<b>Application Ref:</b>	3/2025/0372			 <div>Ribble Valley Borough Council</div> <div><a href="http://www.ribblevalley.gov.uk">www.ribblevalley.gov.uk</a></div>
<b>Date Inspected:</b>	N/A	<b>Site Notice:</b>	N/A	
<b>Officer:</b>	LW			
<b>DELEGATED ITEM FILE REPORT:</b>				<b>REFUSAL</b>

<b>Development Description:</b>	Non-material amendment to 3/2022/0758 involving the addition of door, window and stair to south elevation.
<b>Site Address/Location:</b>	Plant Tree Cottage, Chipping Road, Chaigley, BB7 3LT.

Client:		
Mr S Jackson		
Project:		
Proposed Garage Planetree Cottage Chipping Road Chaigley		
Dwg title:		
Proposed Floor Plans		
Scale @ A4:	Date:	Drawn by:
1:100	28.11.21	PD
Drawing no.		Rev.
1319 - 01		C

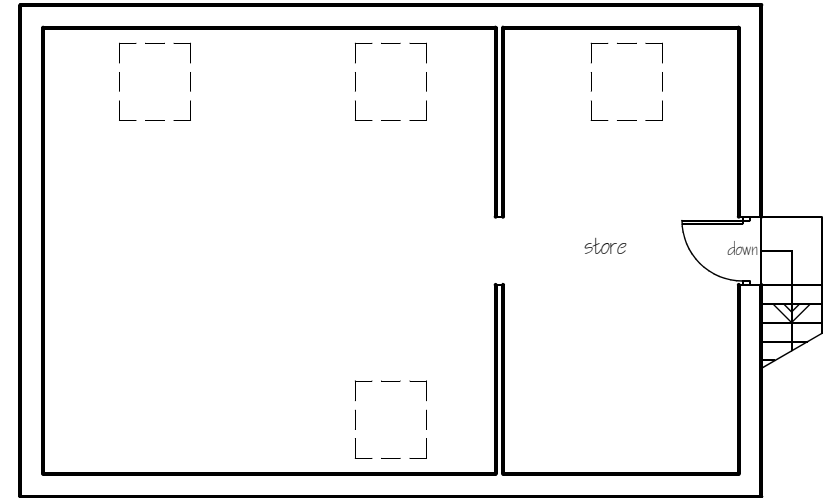
The amendments sought as part of this non-material amendment application relate to an alteration to the southern facing gable elevation of the building, comprising the addition of a ground floor window and external staircase leading up to a personnel door providing access to a first-floor store. This elevation fronts Chipping Road, with the alterations proposed thus introducing new openings and an external staircase to a visually prominent elevation currently devoid of any openings.

The provision of new openings and an external staircase providing access to a first-floor element would increase the domestic appearance of the originally approved single storey garage outbuilding and would erode the revisions sought following the refusal of application 3/2022/0195 and 3/2021/1289.

Accordingly, it is considered that the visual impact of the amendments sought would result in a fundamental change to the design and external appearance of the development originally approved, with the amendments proposed resulting in a development that would be materially different in terms of design and external appearance to that of the original consent.
